From: noel bosw [REDACTED]
Sent: 16 January [REDACTED]
To: Planning.Res [REDACTED]
Subject: nb019112: 1 orchard way + Re: Further Information Required on Your Ref: PP-08405818 Our Ref: WA/1/20/HH

Please confirm in writing your acceptance of the amended description.
Single storey front extension,provision of a multi fuel stove and flue, new rendering/cladding to all elevations and addition of a front dormer.

nb:19112+100a

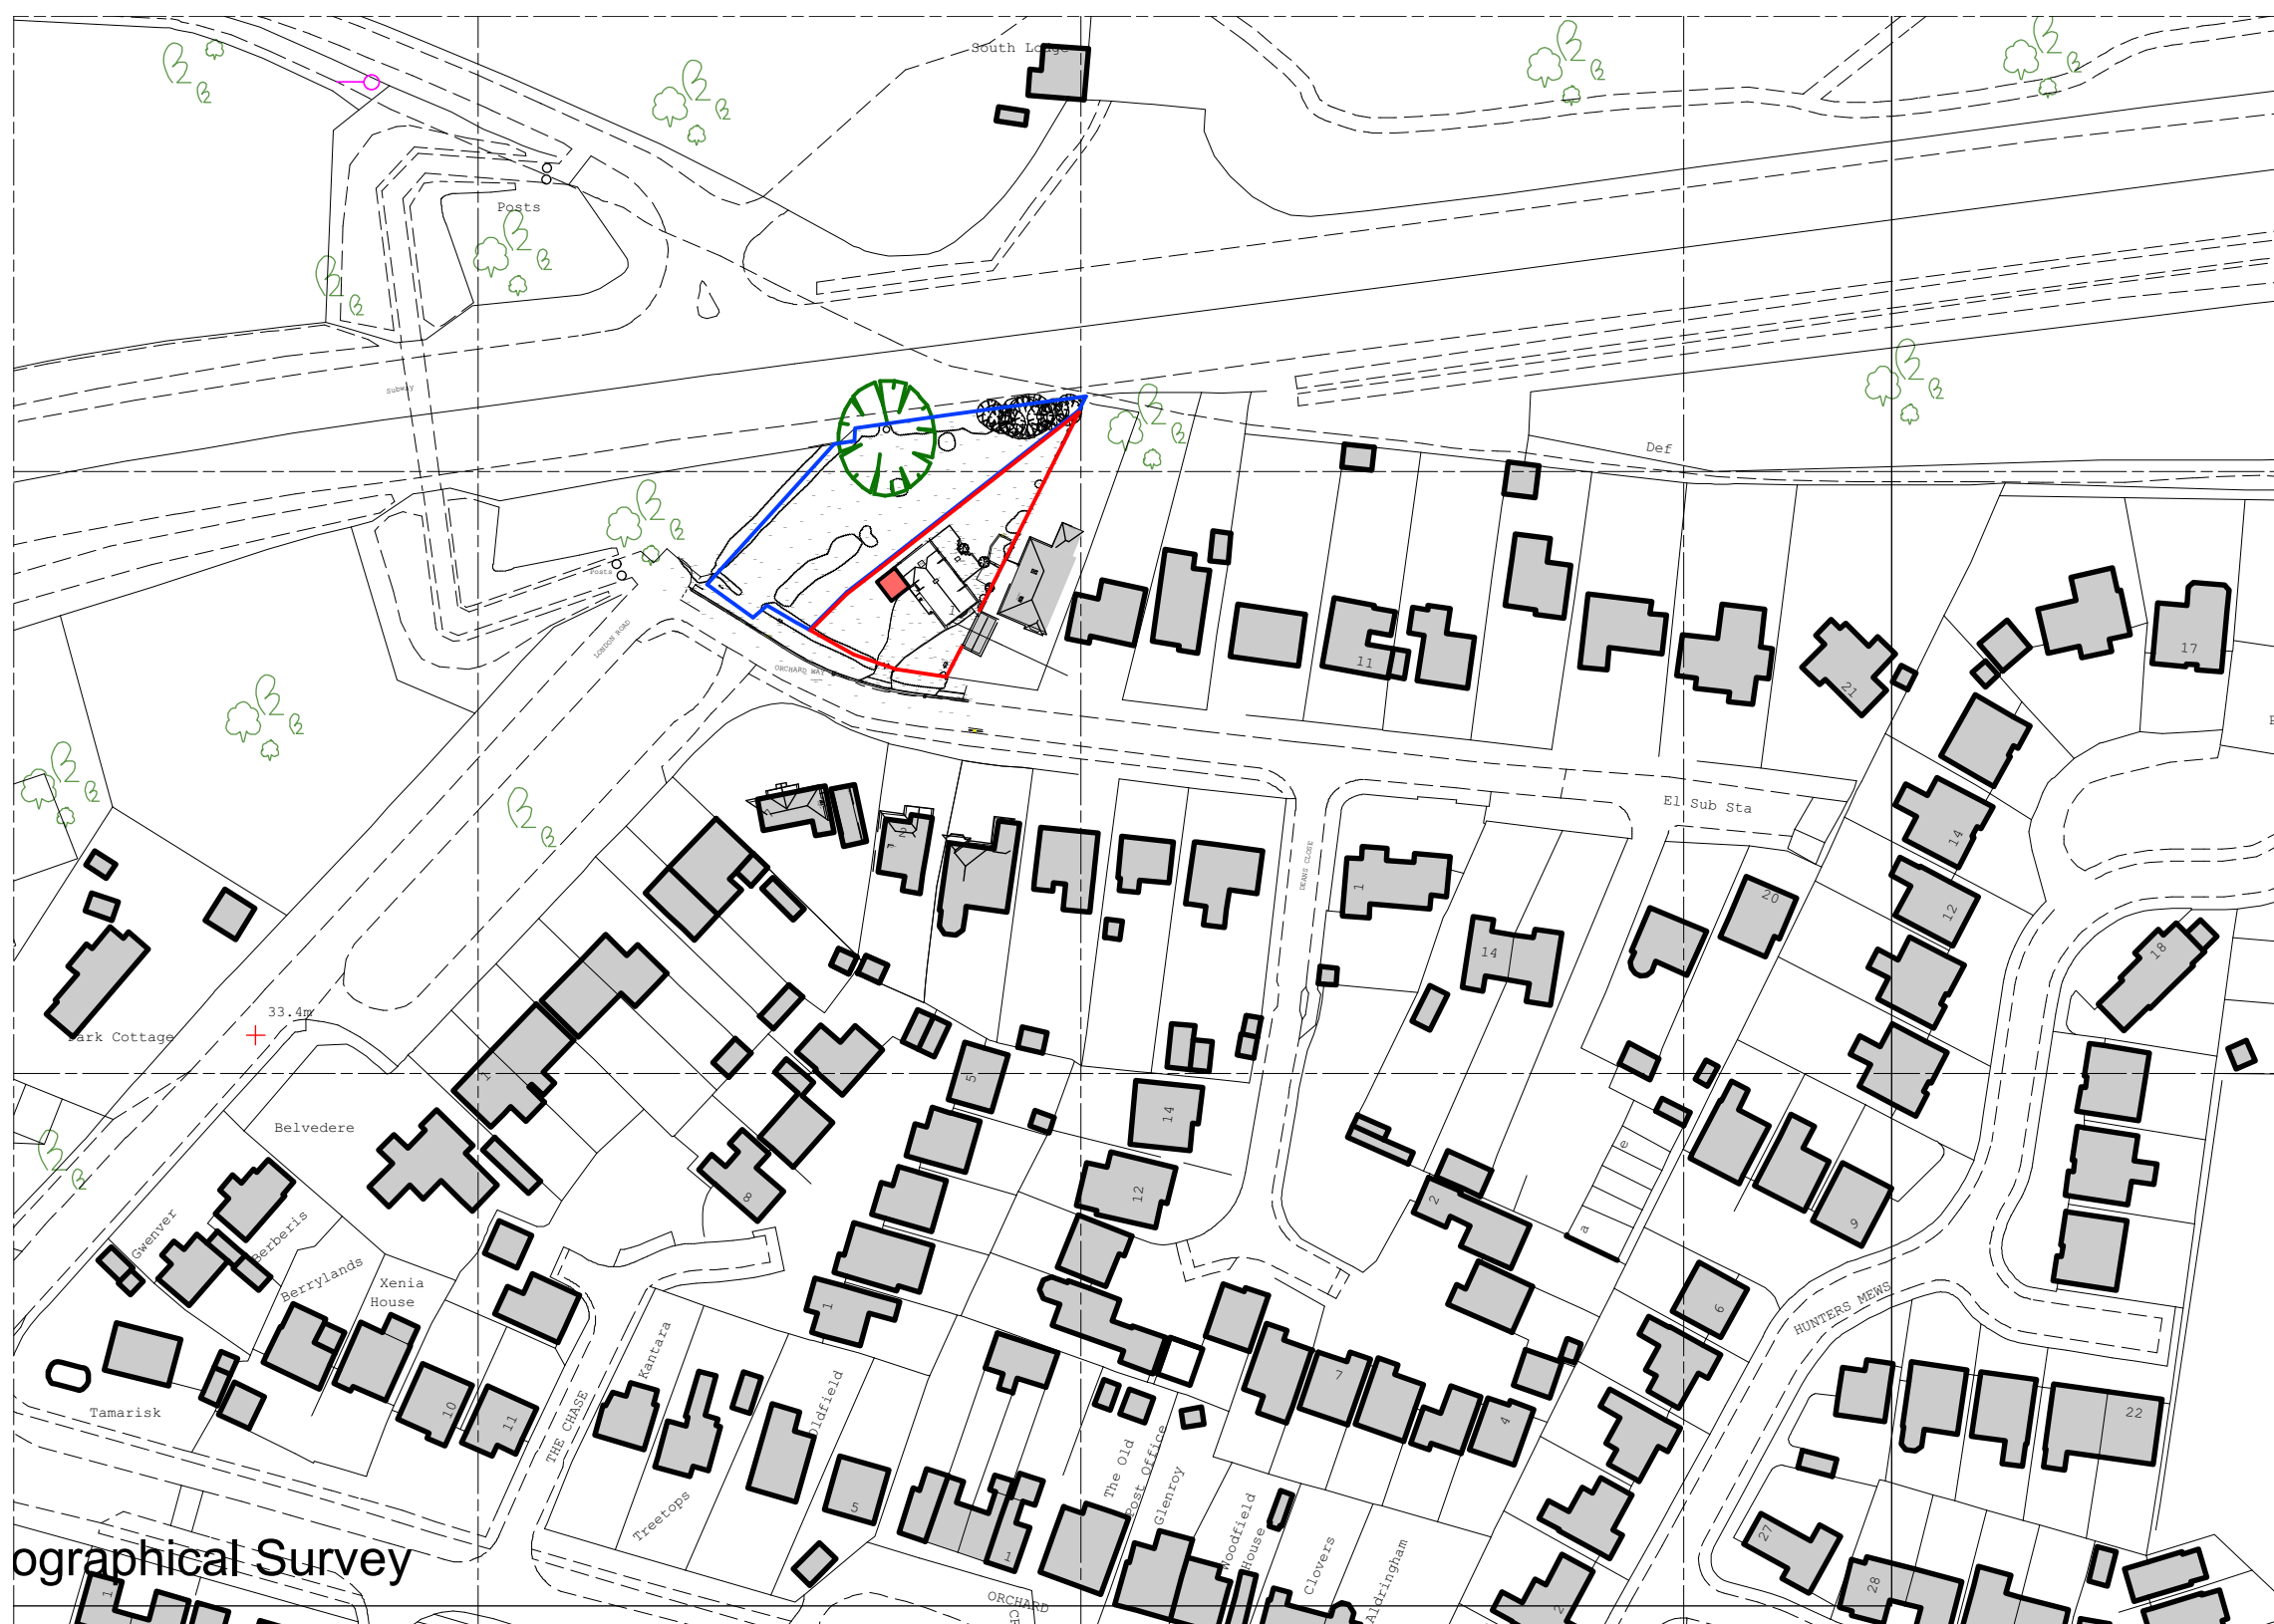
Location Plan: You are required to include the entire site within the red outline on the location plan.

Block Plan: You are required to include dimensions on the block plan from the proposed extension to all site boundaries.

UPDATED PLAN ENCLOSED

UPDATED PLAN ENCLOSED
